From: Laura Gibbons <Laura.Gibbons@arun.gov.uk>
Sent: 16 November 2021 09:24
To: Planning.Responses <Planning.Responses@arun.gov.uk>
Subject: RE: Planning Consultation on: BE/160/21/DOC

Engineers Comments Regarding Condition 12

Site Address: Land At Salt Box West Of Shripney Road Bognor Regis PO22 9NW

Description of Works: Approval of details reserved by condition imposed under BE/135/18/PL (full planning application) relating to conditions 12-surface water drainage scheme, 13-discharge of flows, 15-as-built drawings & 16-foul water drainage system.

PROPOSED DRAINAGE - STORM

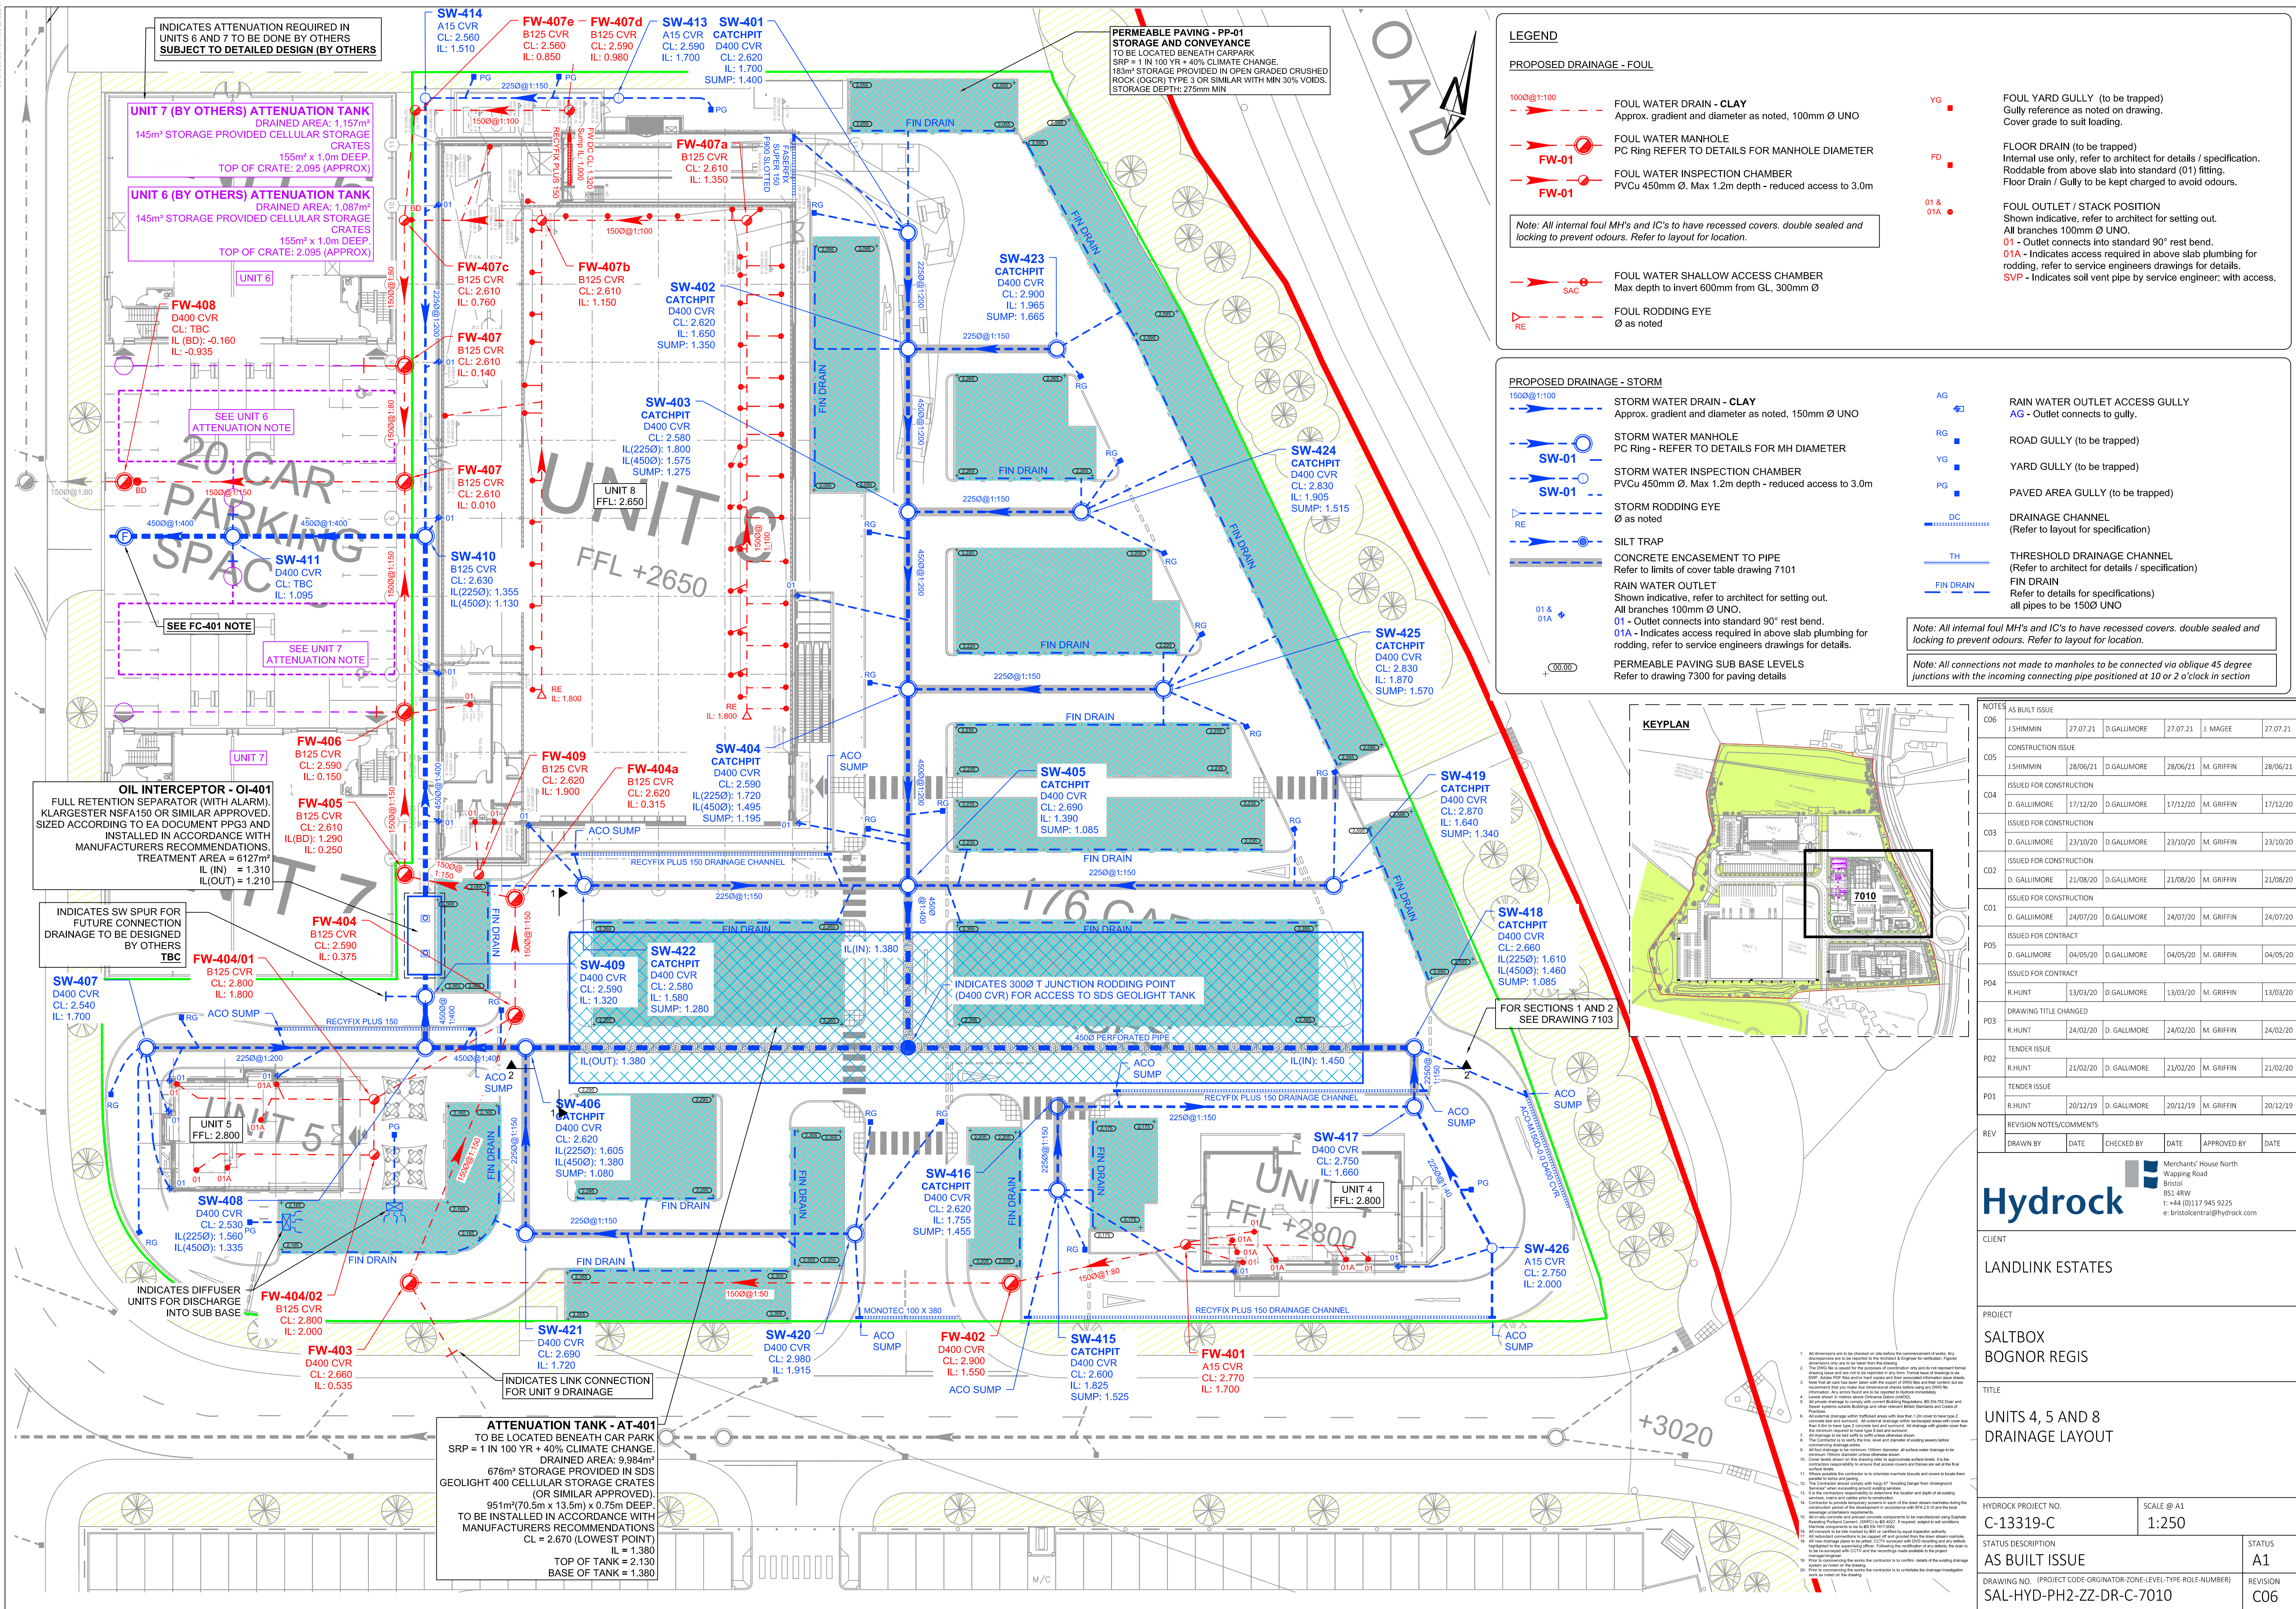
Several pipes have been constructed very slack. For example the pipe downstream of SW-503 is a 450 diameter pipe, and has been constructed at 1:636. This is not suitable. All pipes should achieve 1m/s velocity.
